RE: Fielder Variance Application (VA-20-00014) – Response to Comments

Parcel No.: 486835

① Site
 1" = 20'-0"

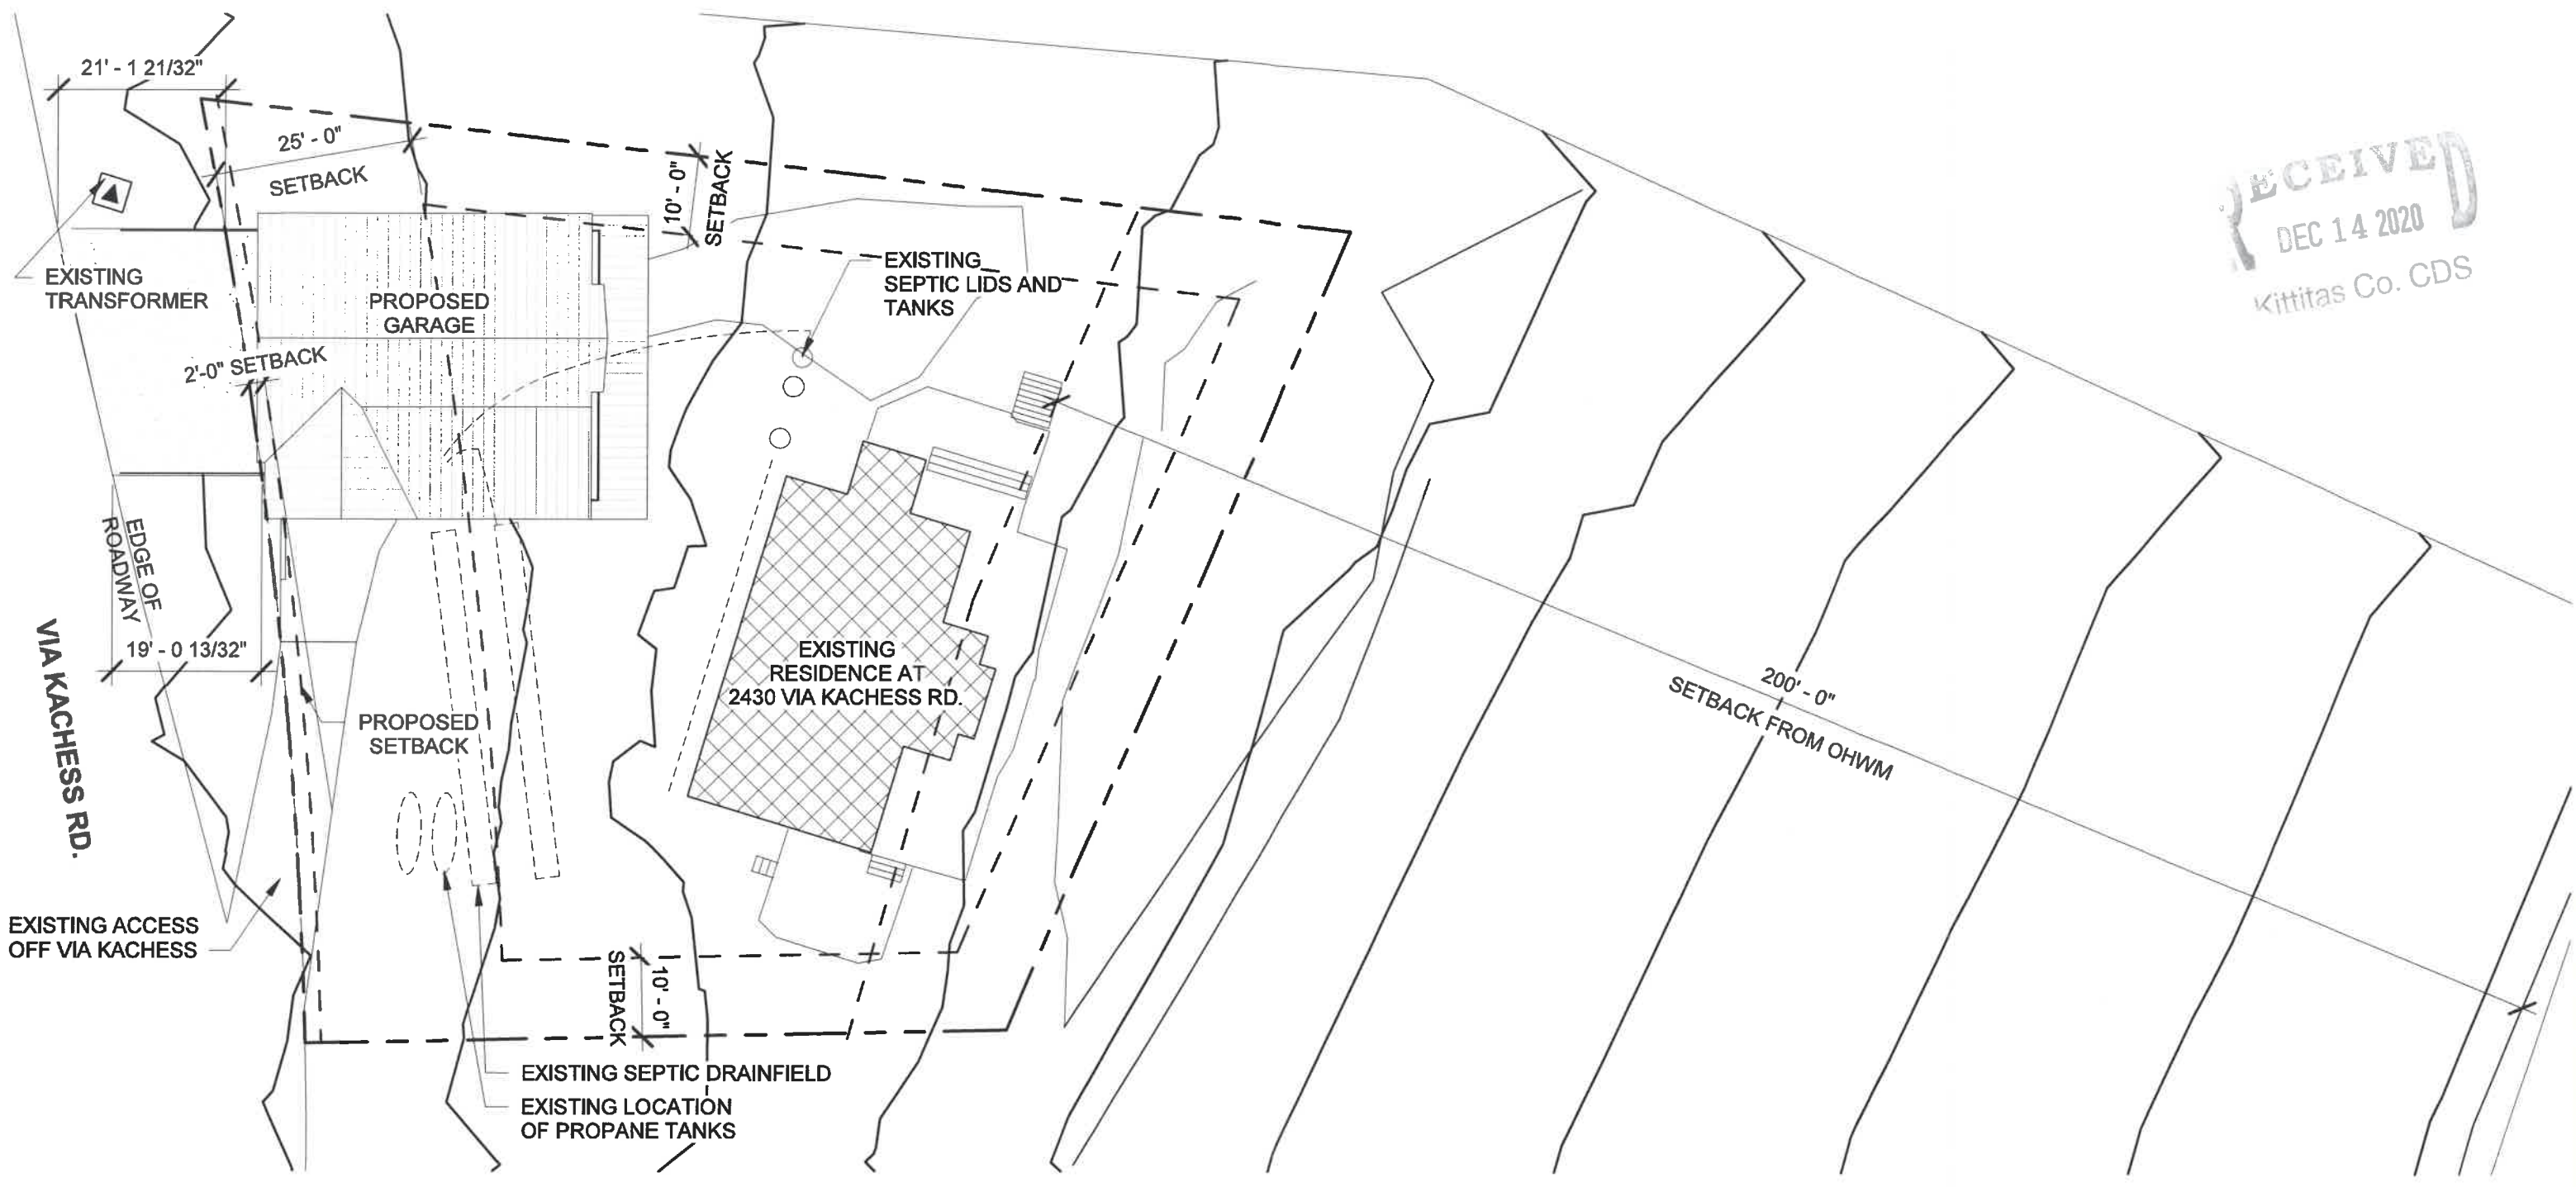
- Washington Department of F&W – Scott Downs; February 10th, 2021
- Kittitas County Public Health – Holly Erdman; February 16th, 2021
- Department of Archaeology & Historic Preservation – Sydney Hanson; February 16th, 2021

In response to Fish and Wildlife a note will be added to the site plan when submitting for a building permit, "The current setback shown on our site plan will be maintained from Lake Kachess and its riparian area and will not be modified if further iterations are needed to the proposed structure."
